Approval of details reserved by condition imposed under ref A/76/20/PL relating to Condition Nos 17 - existing & proposed ground levels, proposed finished floor levels, levels of any paths, drives, garages & parking areas & the proposed completed height of development & any retaining walls, 18 - surface water drainage, 19 - maintenance & management of surface water drainage, 21 - discharge flows to watercourses and 22 foul drainage system.

Land at Dappers Lane Angmering Littlehampton

Arun District Council have decided to **REFUSE details reserved by condition for the following reasons:**

Title **Volumetrics Assessment**

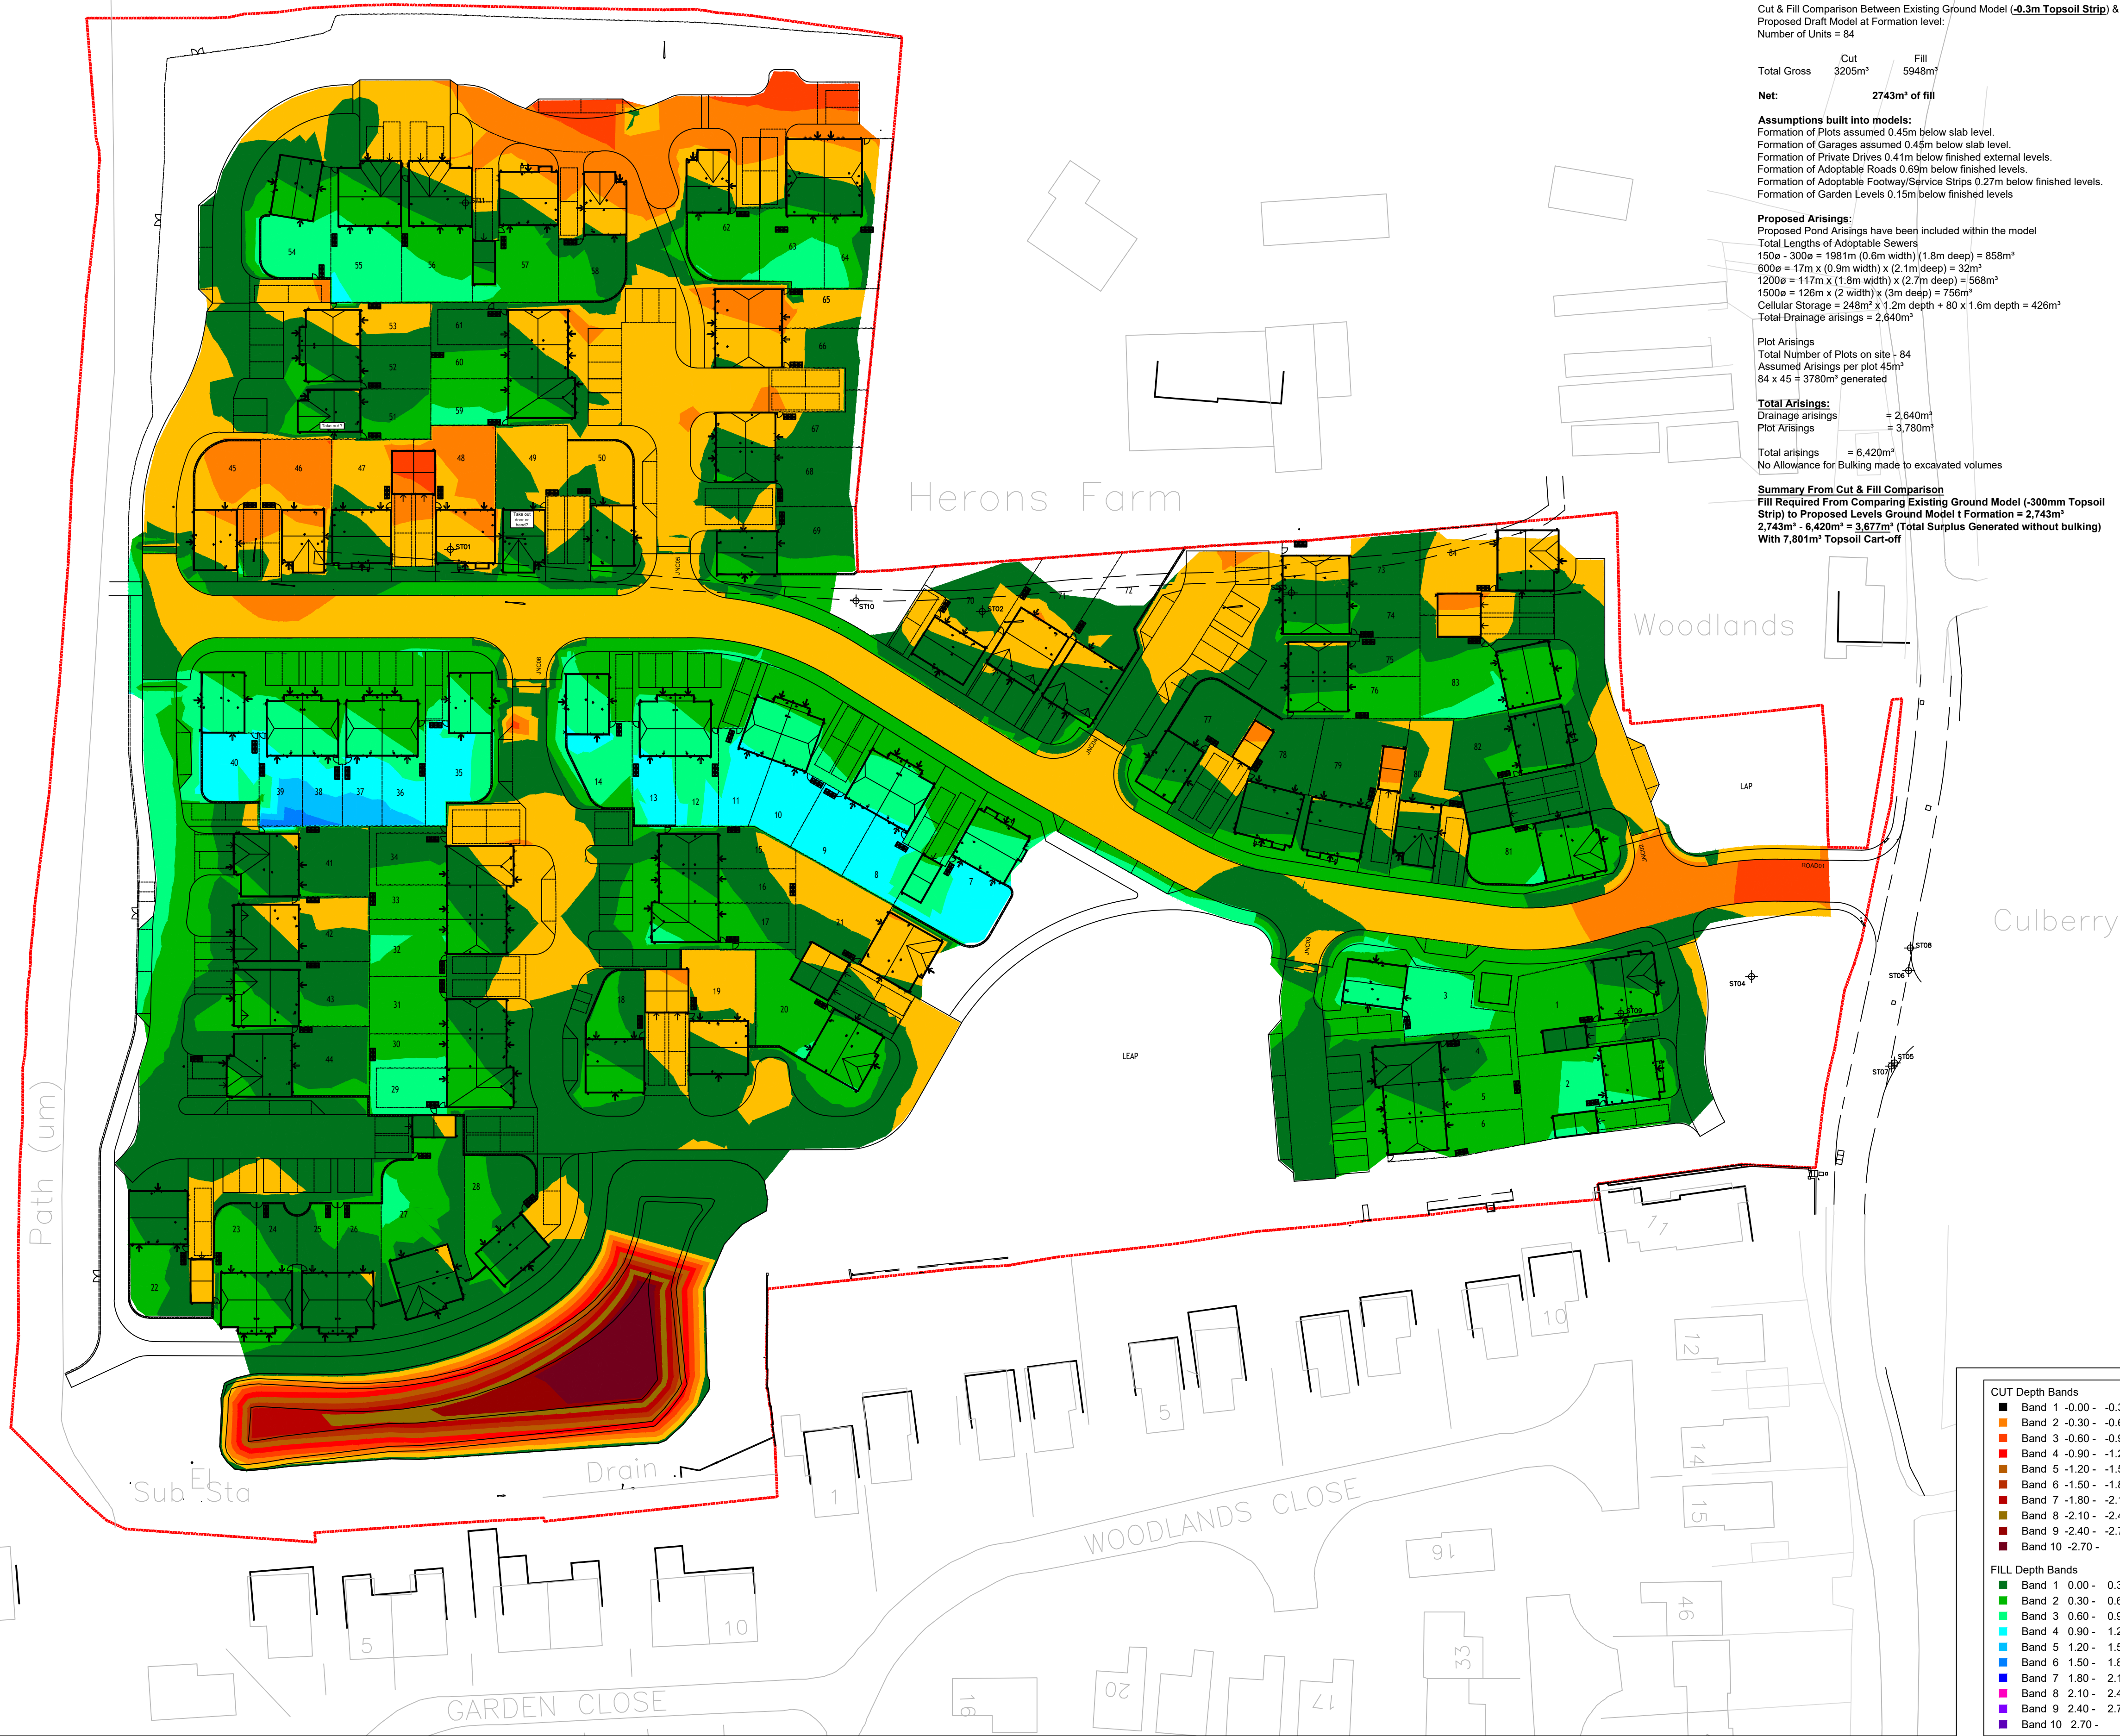
- Significant land raising of circa 1.0 metre is proposed. The impacts of any such proposals on adjacent sites have not been provided in terms of surface water run-off and groundwater levels. Land raising should be reduced and evidence should be submitted to demonstrate that run-off will not shed off-site.
